Fort Street Public School (SSD-10340)
Request for Additional Information

I refer to the development application for the Fort Street Public School (SSD-10340). After careful consideration, the Department is requesting that you provide additional information.

title
Landscape
Landscape Sections

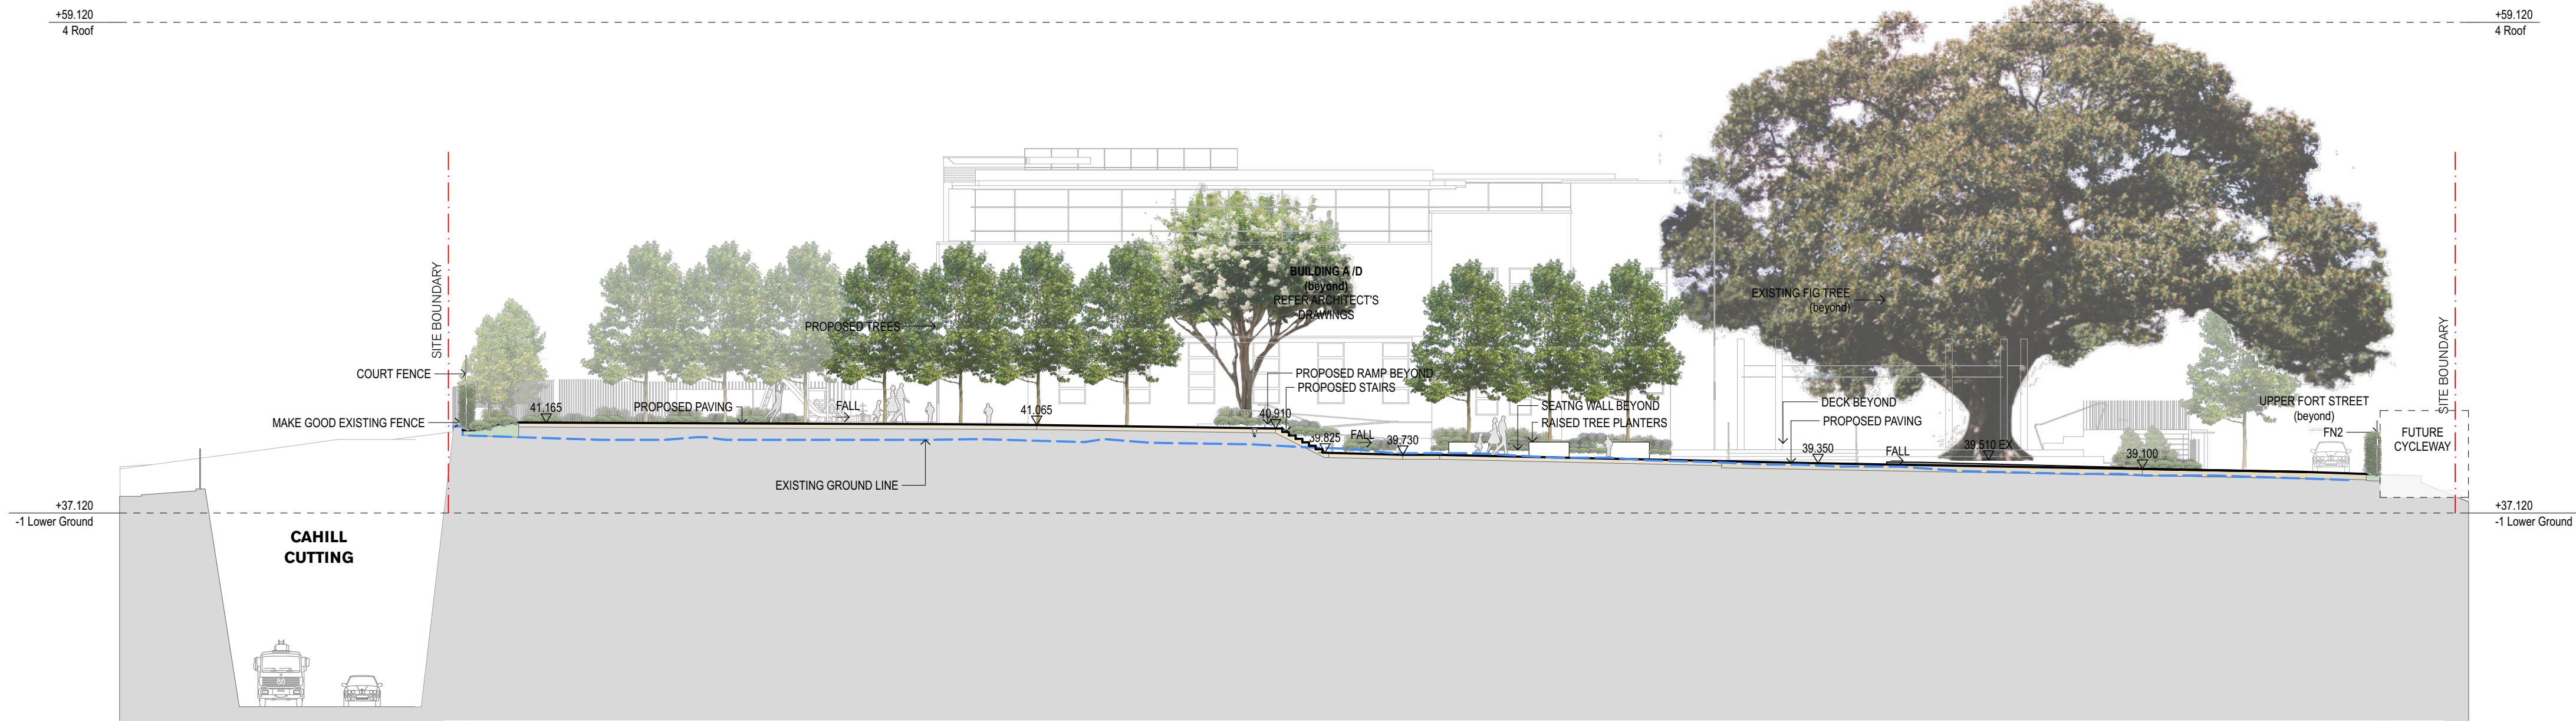
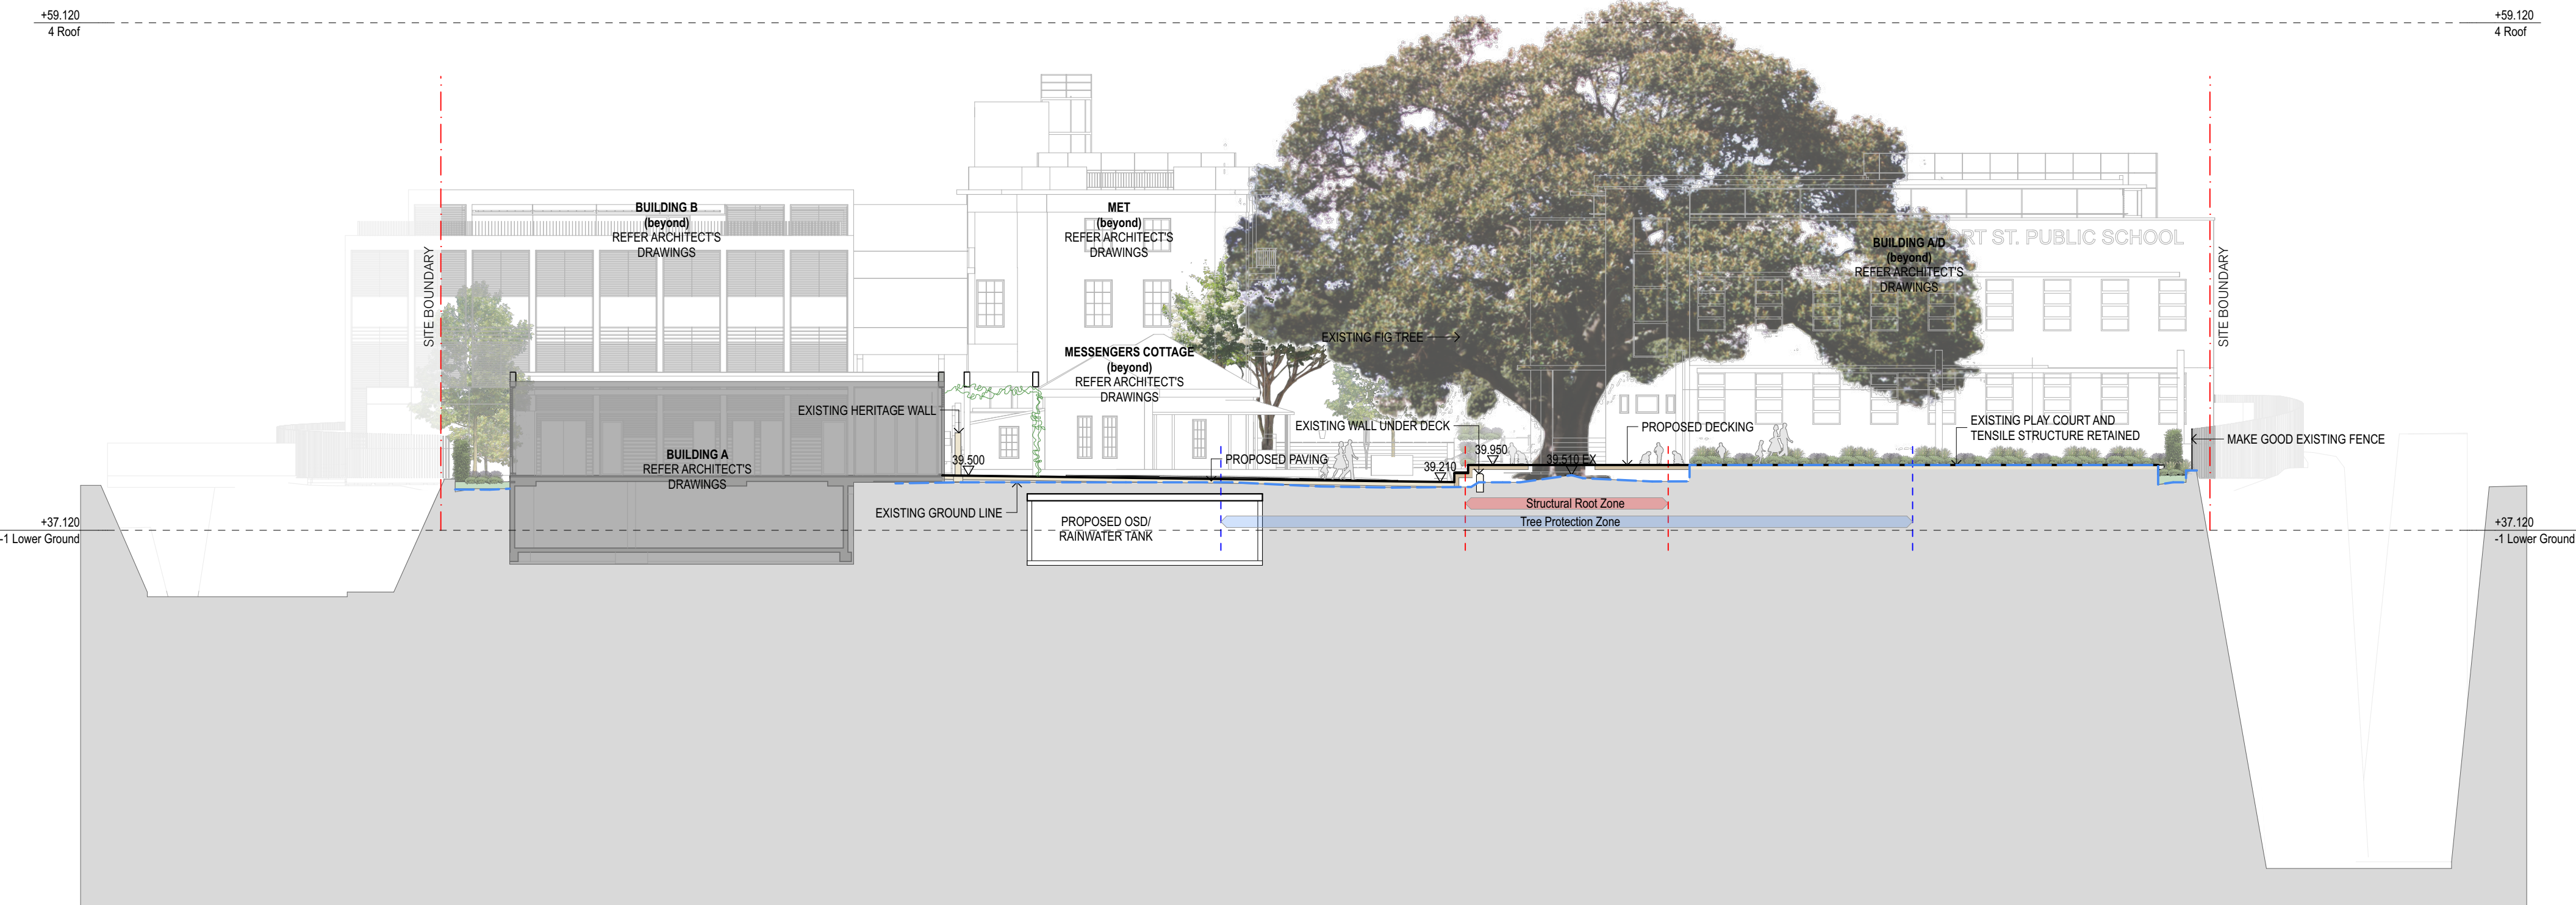
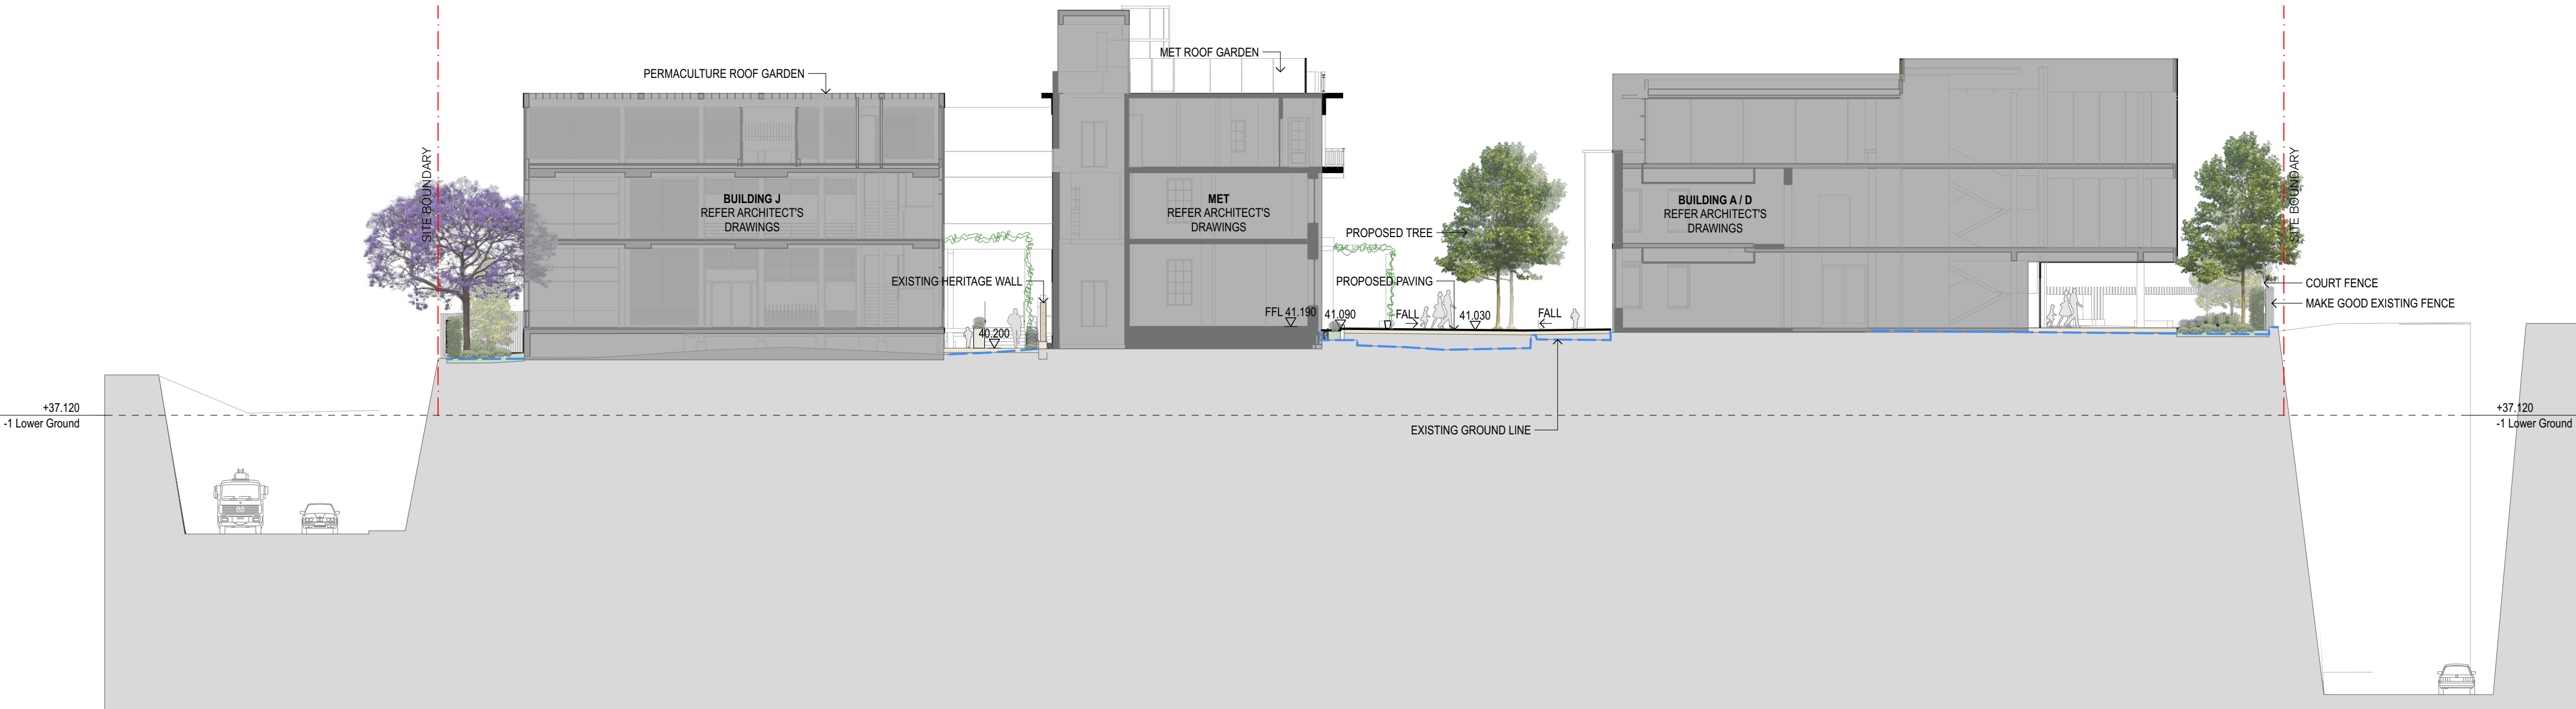
- updated landscape plans that confirm the interim and permanent landscape and fencing treatment at the front of the school, detailing proposed treatments before and after any upgrades to the Sydney Harbour Bridge – Kent Street cycleway/walkway;
- plans and details of proposed fencing types, materials and colours;
- amended architectural and landscape plans and/or justification in relation to additional tree retention as per Council's request to the Response to Submissions (see attached);
- statement addressing the types of community uses proposed for the accessible roofs and outdoor areas; and
- confirmation of end-of-trip facilities to be provided / available on site and if applicable, the location of and types of facilities provided.
